Application No: K/16/21/HH
Site Address: Sea Lodge 7 Coastal Road Kingston BN16 1SJ
Description of works: Internal alterations to existing dwelling. Demolition and replacement of existing rear extension with new single storey extension and first floor terrace above with external staircase. Replacement of main roof and 4no. new dormers with windows. Replacement roof tiles to single-storey projections on North elevation. Proposed rear single storey minor extension to garage to form entrance lobby. Alterations to external facade of house and replacement windows and doors throughout. Associated landscaping to suit.

Thank you for your internet representation made on 27th May 2021 which has been recorded as an objection with the comments as follows:

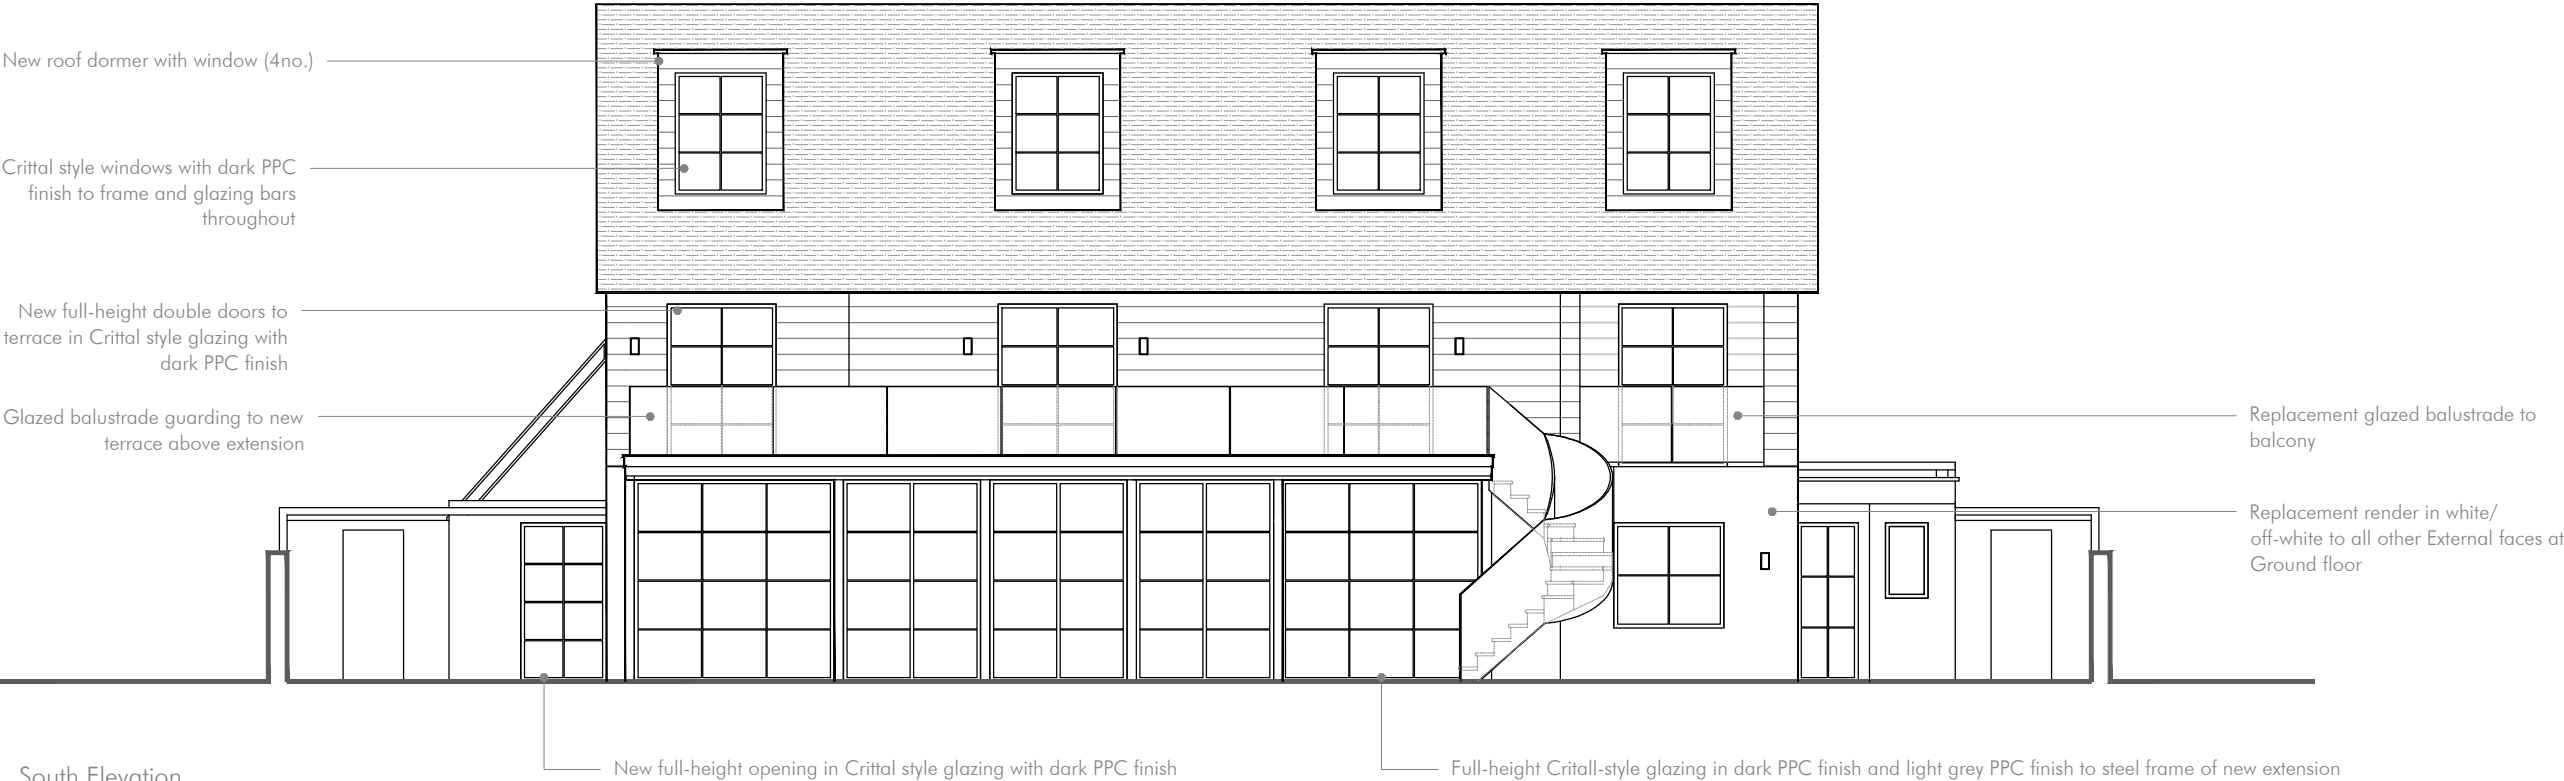
Roof height will be above current height of houses surrounding and next door.
